**RE: REQUEST FOR FURTHER INFORMATION  
DARLINGTON PUBLIC SCHOOL REDEVELOPMENT (SSD-9914)**

Golden Grove Street - Elevation Comparison

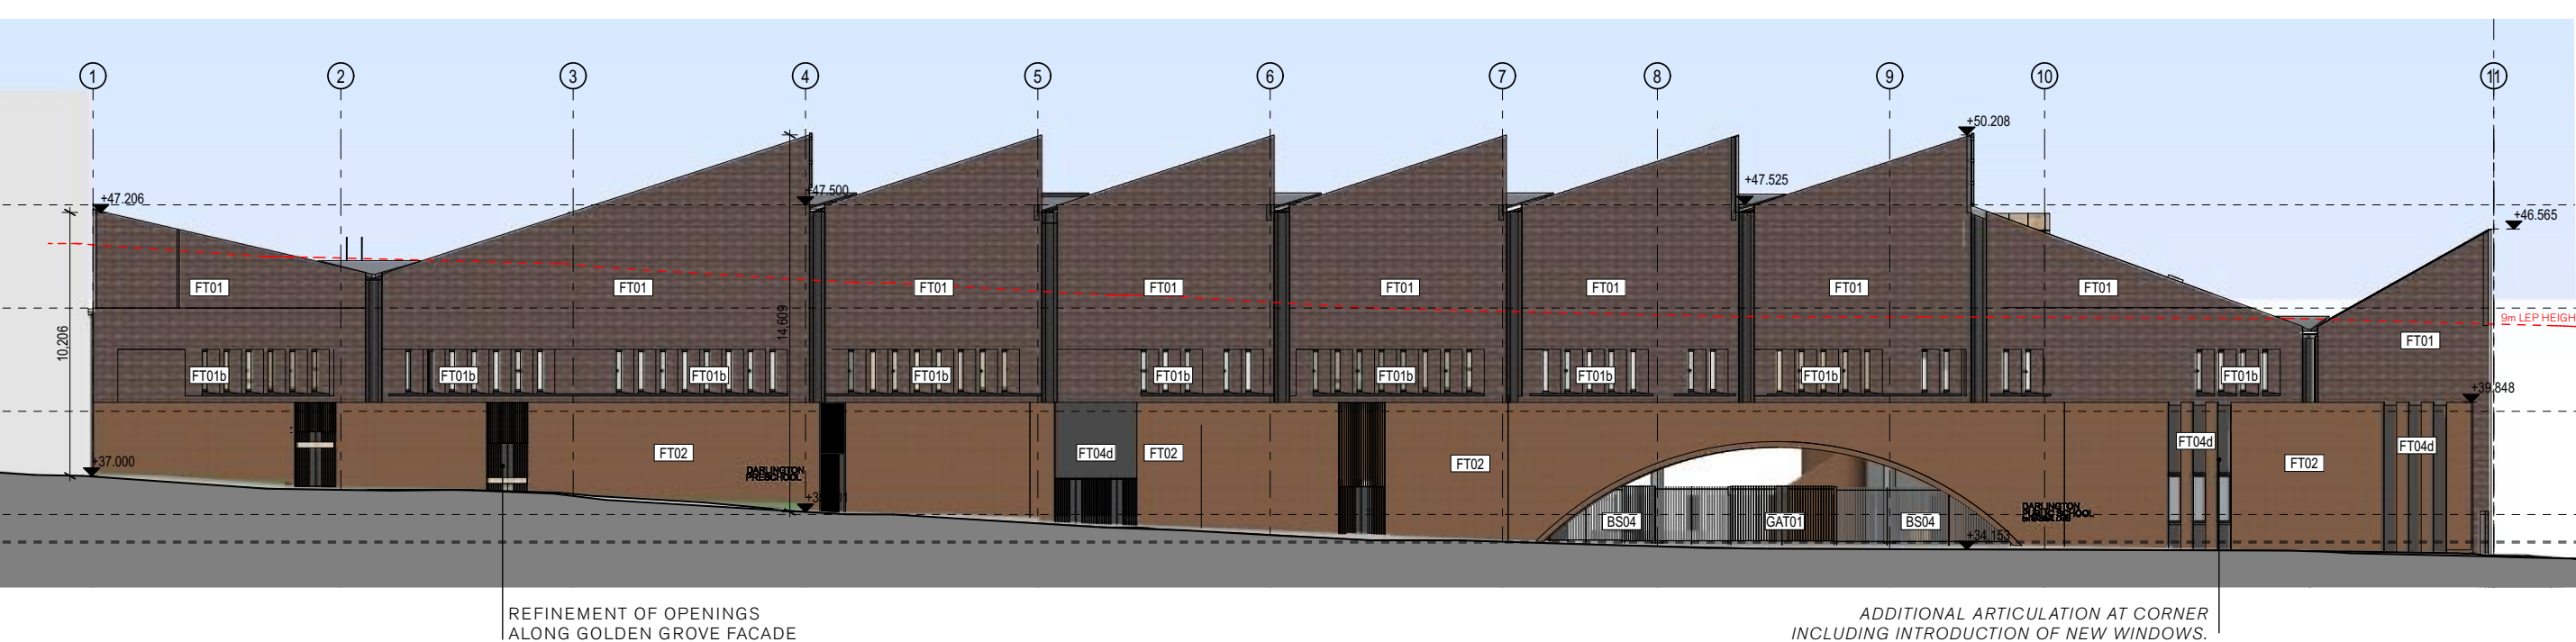
- *The proposed buildings present large blank facades to both Golden Grove and Abercrombie streets. Articulation of the facades, further definition of openings and detailing of materials to positively address the public domain is requested.*

Elevation Comparison

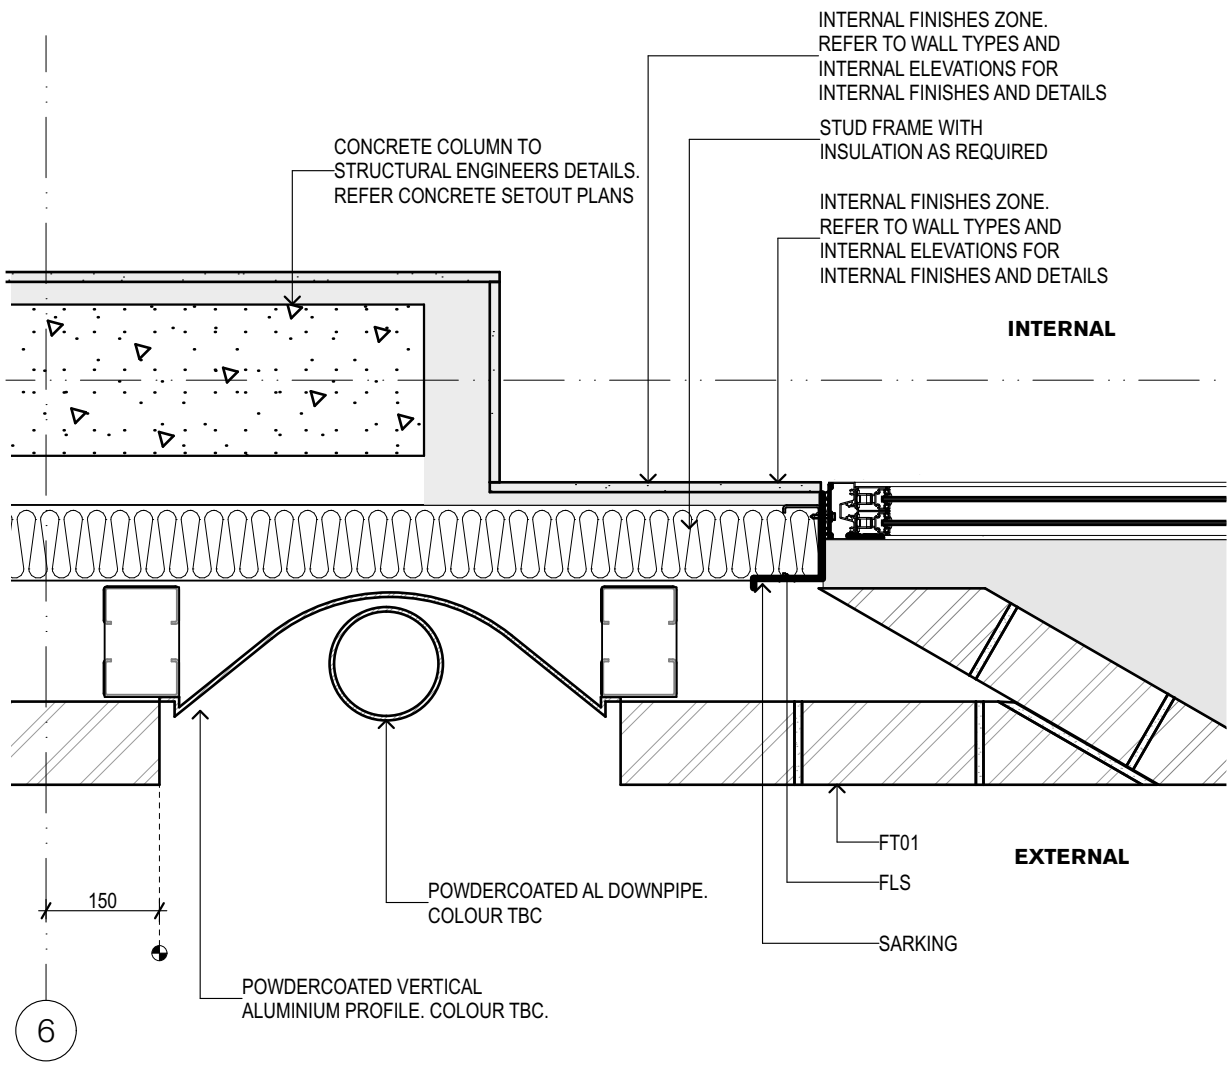
- *The learning block is contained within a 3 story element which appears overscaled. The rationale for clearstory windows and their environmental amenity is understood and accepted, however the forms need to be detailed and articulated to break down the scale of the block.*

Golden Grove Street - Facade Detail

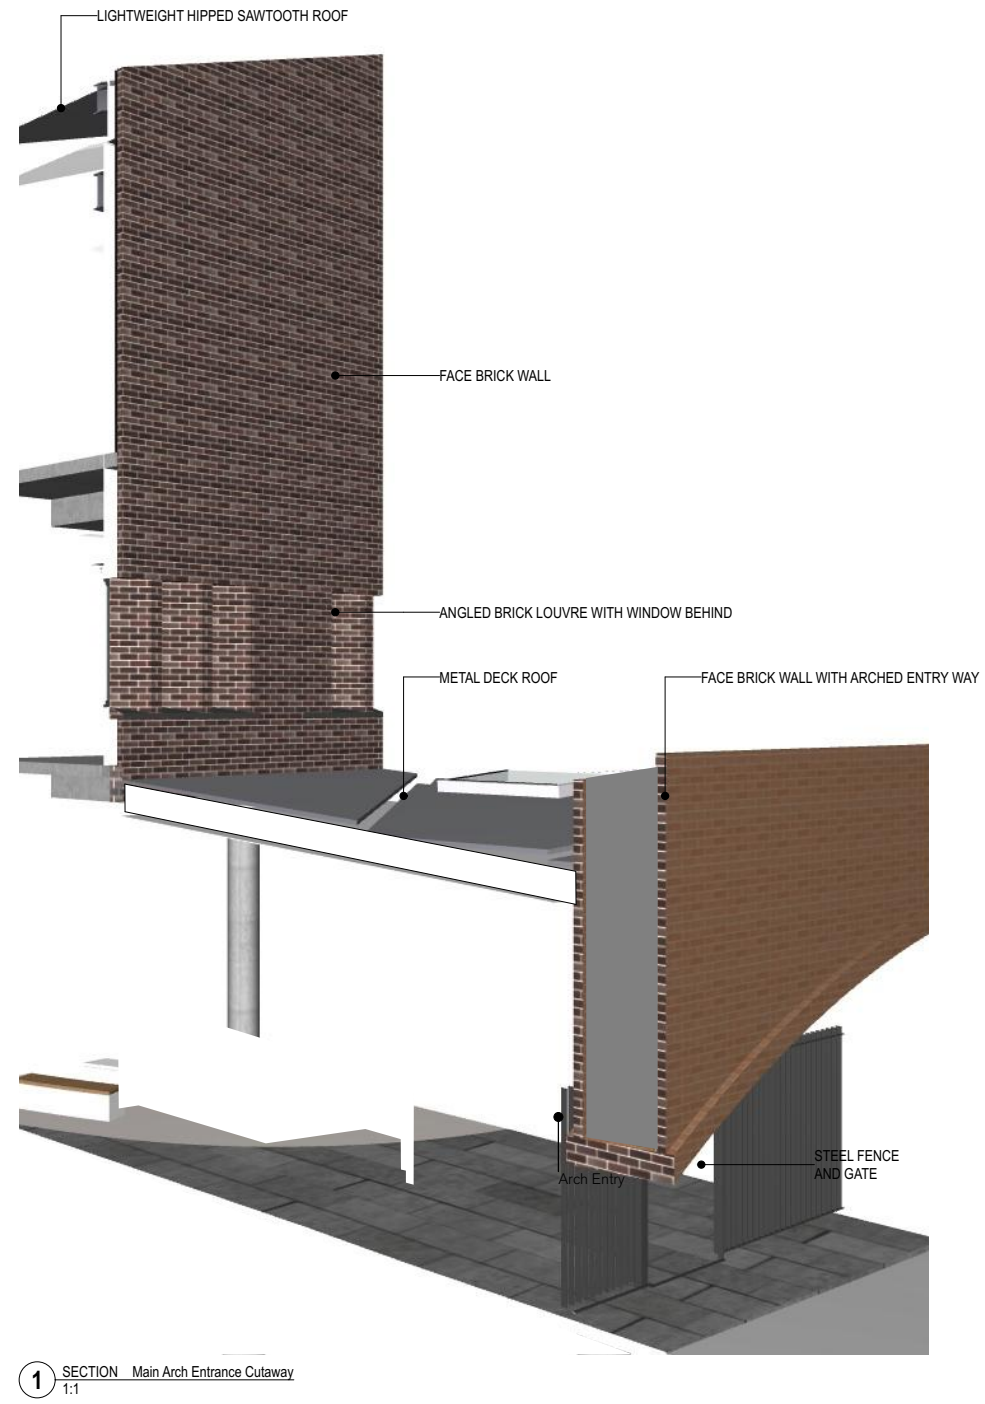
- *The proposed materiality notes brickwork can be patterned to achieve texture and transparency. Further detailing of the building facades is requested to demonstrate how this will be implemented.*

General Arrangement Plans

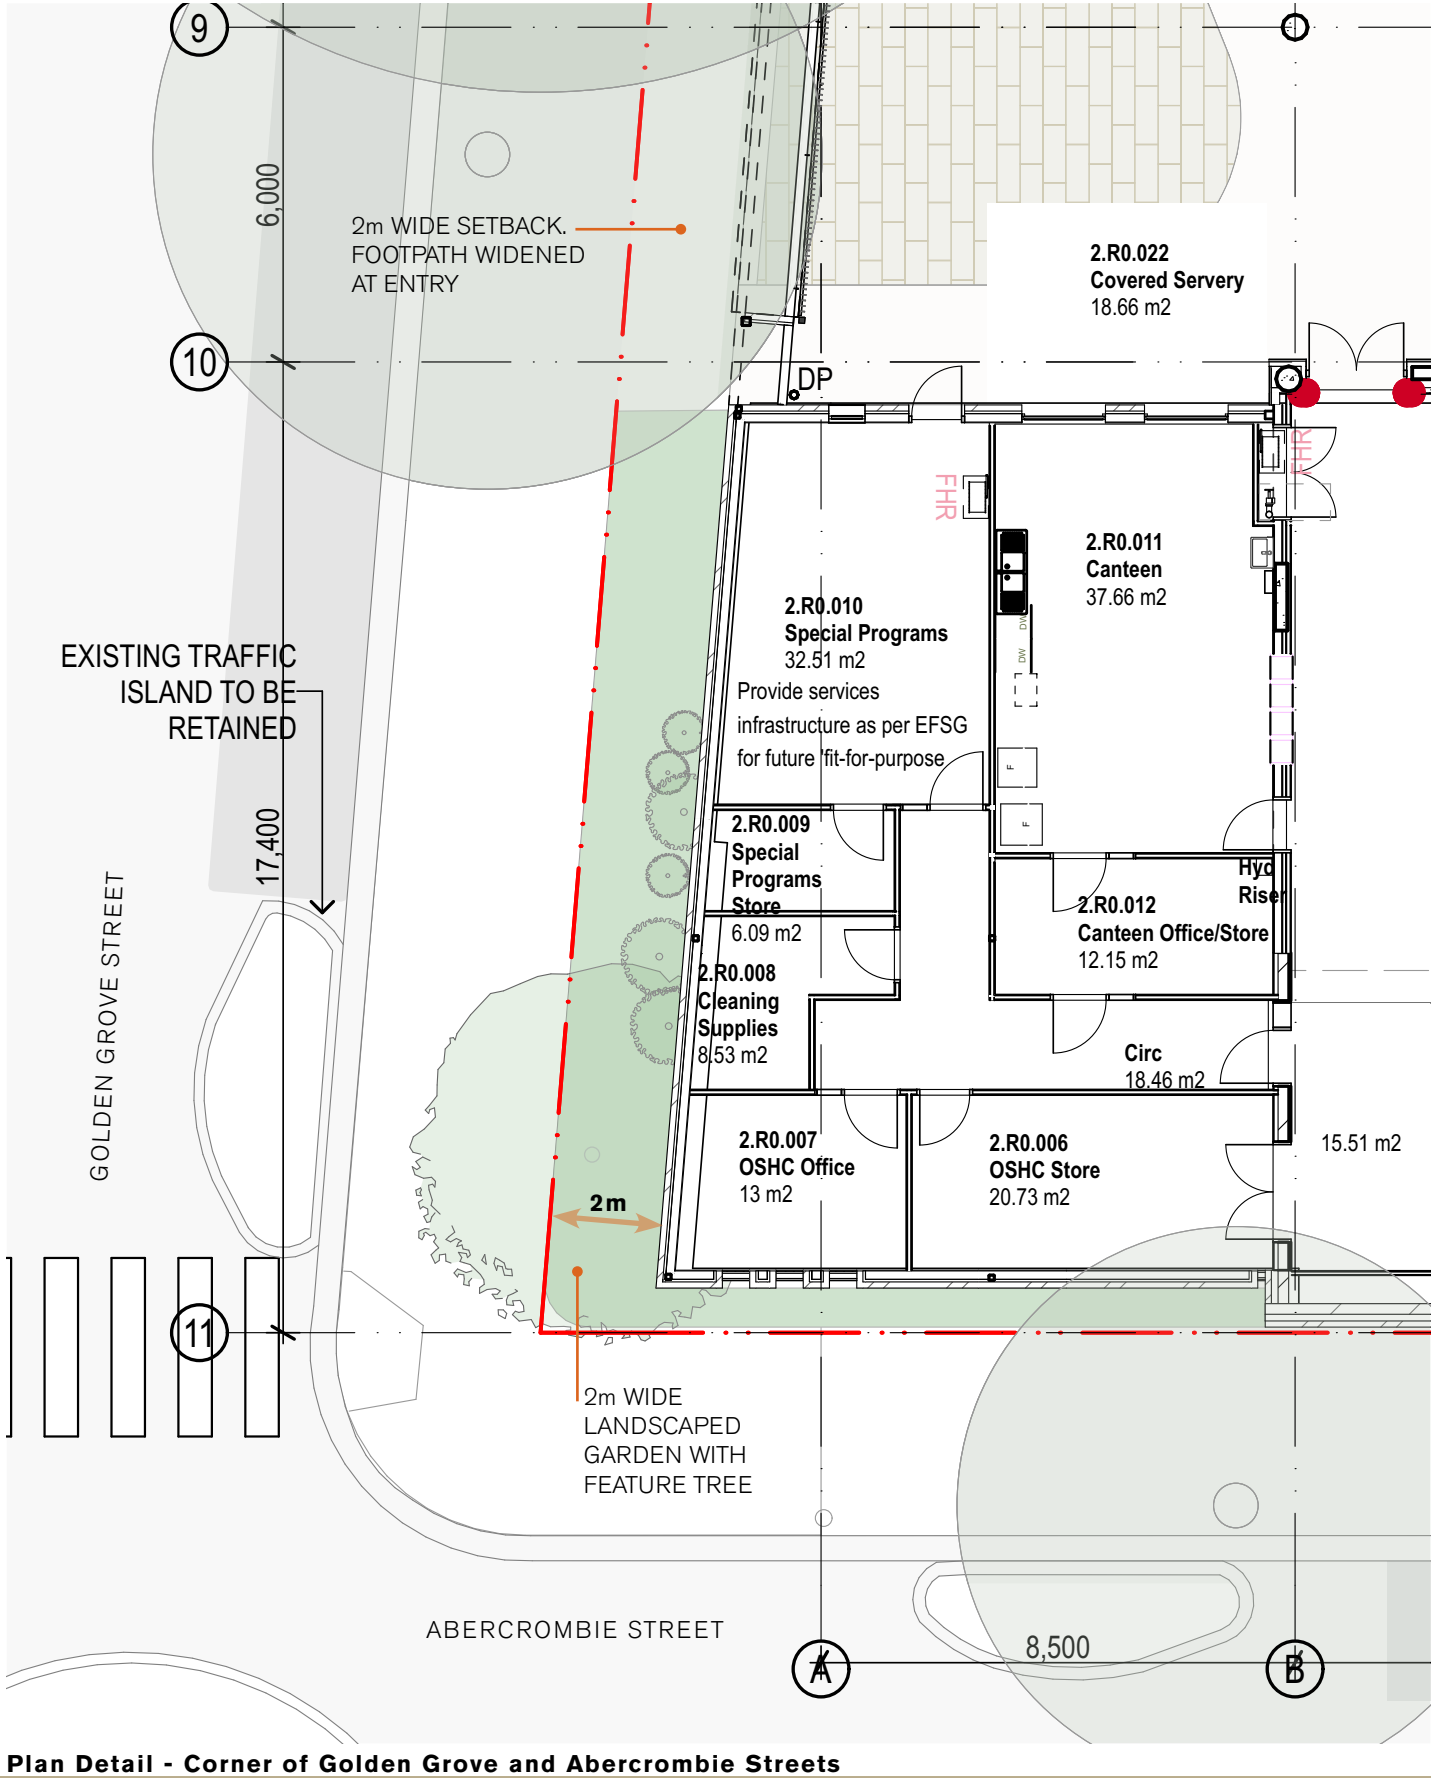
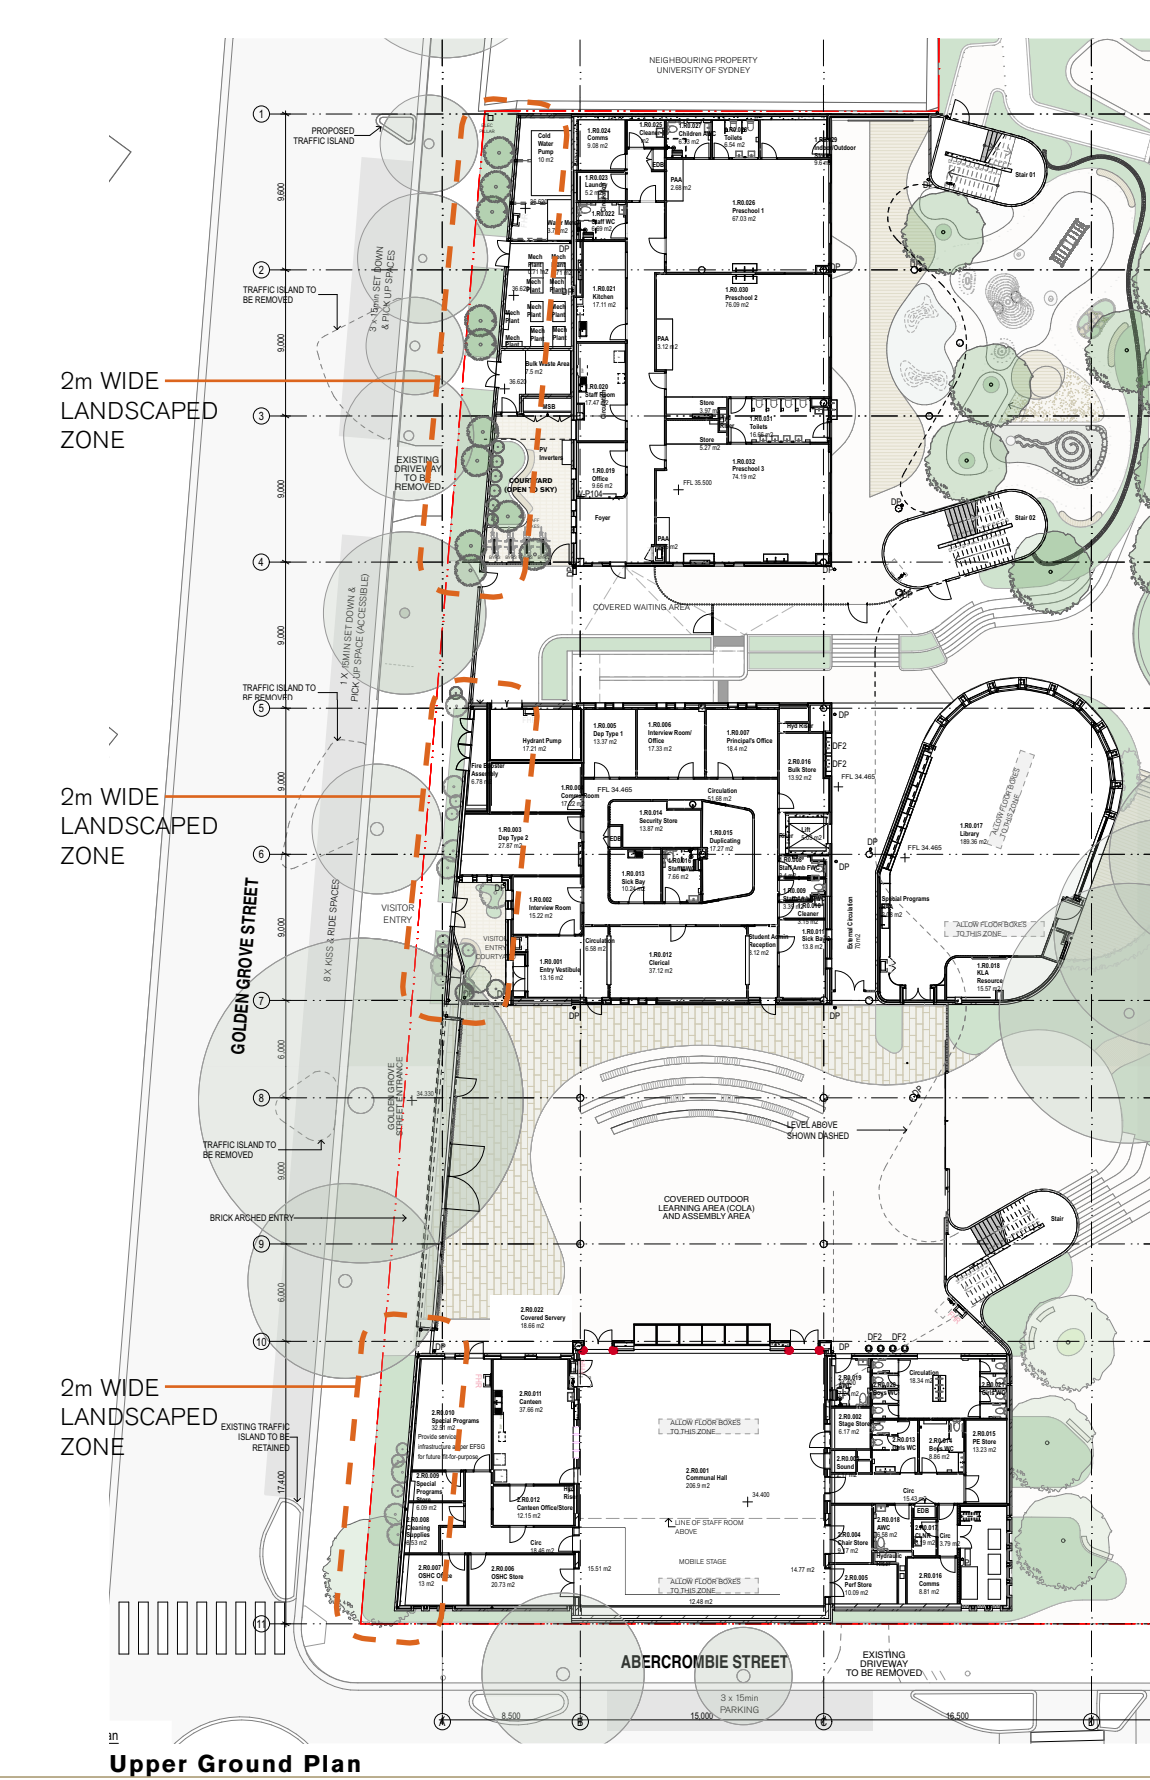
- *The previously included landscaped setback along Golden Grove street has been deleted, and the building no longer engages with the public domain in a positive manner nor does it contribute to public amenity. Articulation of this street edge and the inclusion of public amenity is requested.*
